DEPARTMENT OF PARKS AND COMMUNITY SERVICES

October 20, 2023

Subject: Retreat at TimberRidge Filing No. 3 Final Plat, Review #2 (SF-22-041)

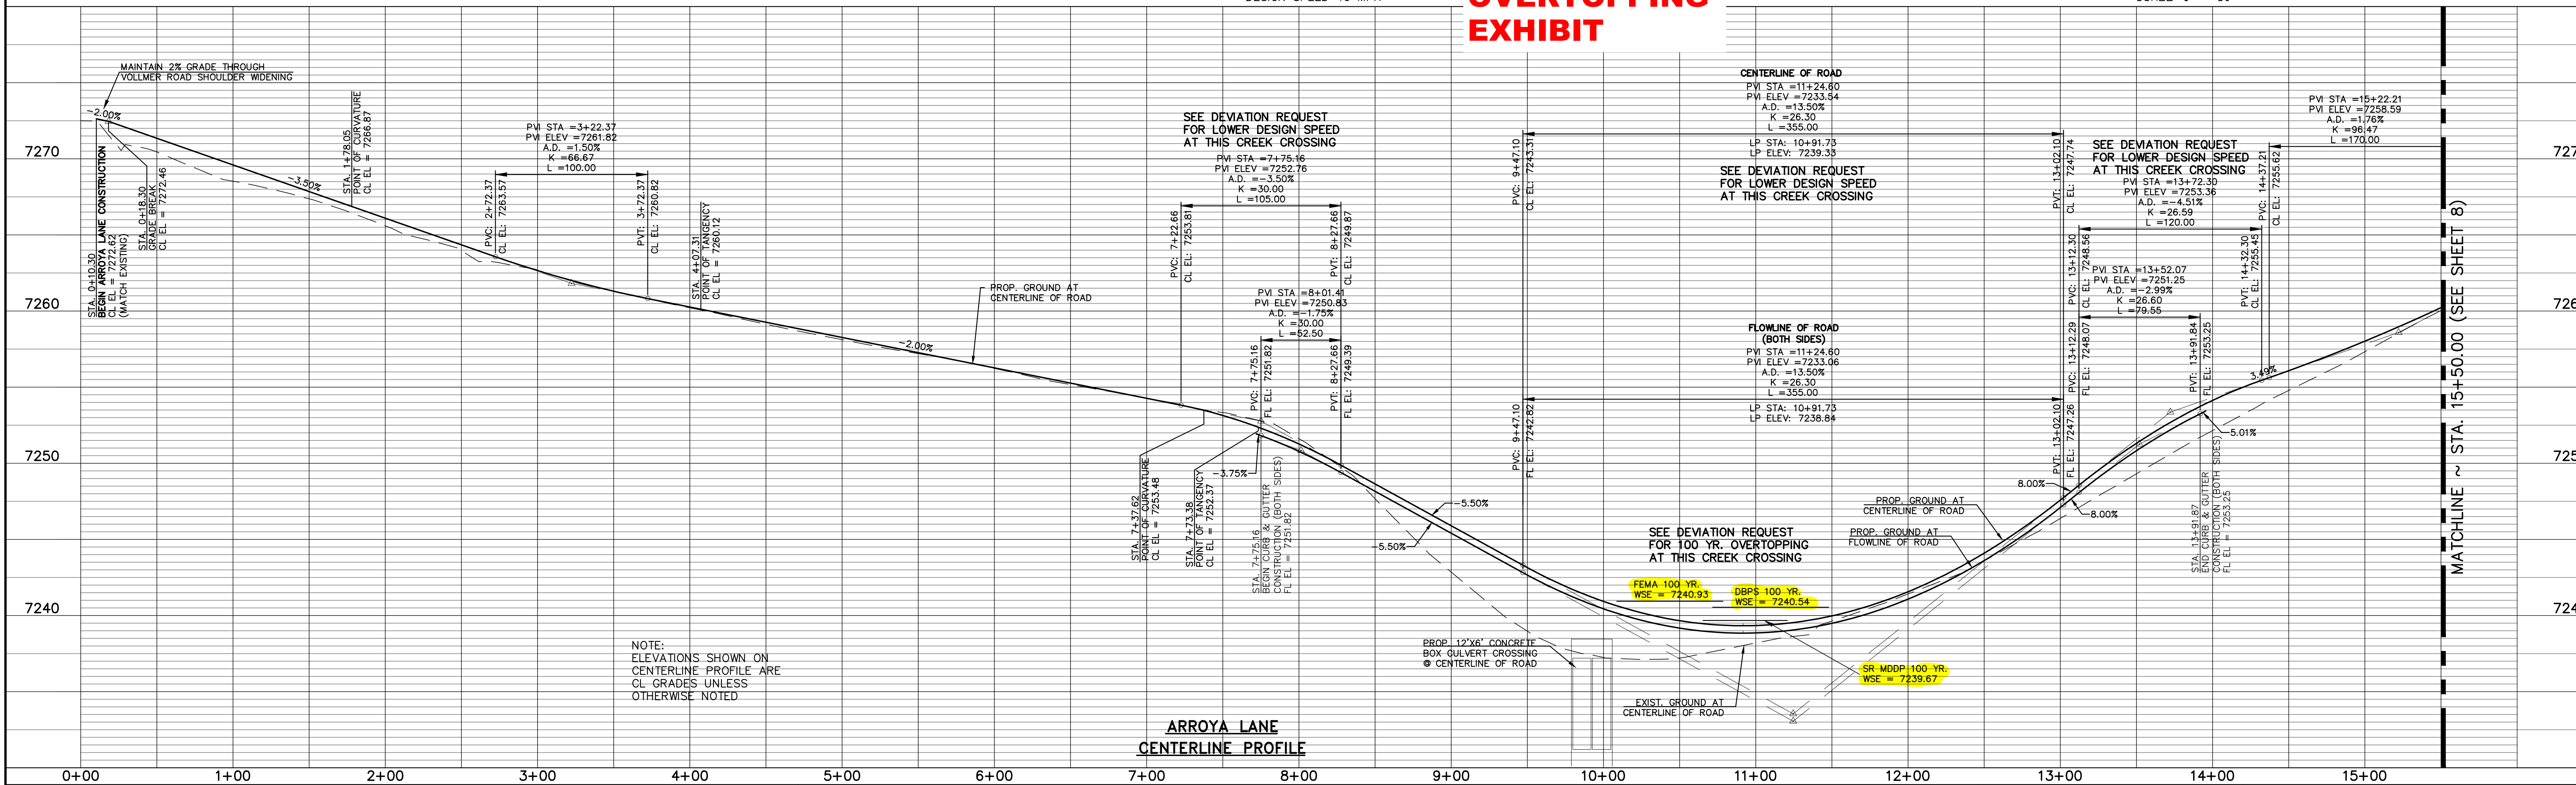
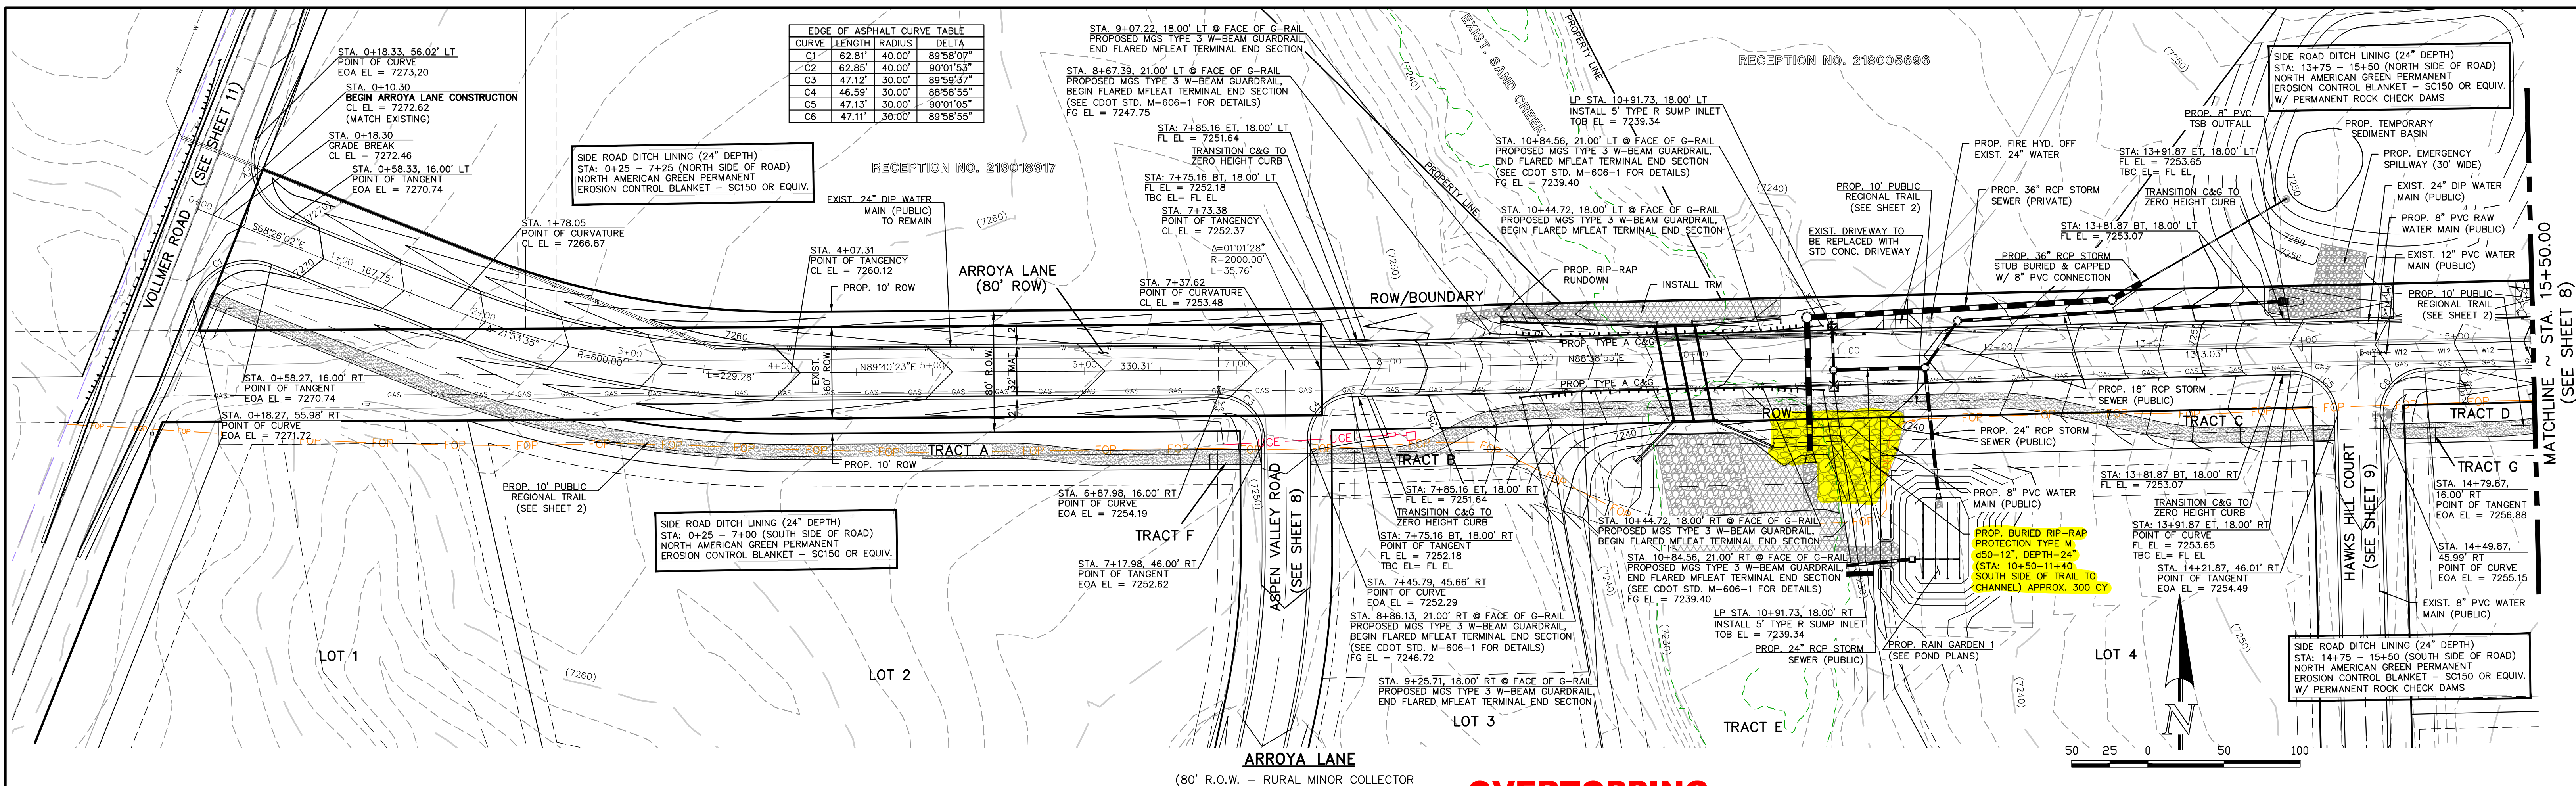
However, if the proposed sidewalk along the south side of Arroyo Lane is intended to serve as the Arroyo Lane Primary Regional Trail, EPC Parks staff requests that it be built to a width of 8 feet to reflect EPC Parks trail standards. According to the construction documents submitted by the applicant, the proposed sidewalk does appear to be approximately 8'-10' wide, as it appears to be the same width as the proposed 10' Arroyo Lane right-of-way, although no definitive measurements are included in the plan. Where the sidewalk exists inside Tracts A-D, the trail easement may encompass the sidewalk. No trail easement is necessary within the Arroyo Lane ROW, where the Arroyo Lane culvert crosses Sand Creek.
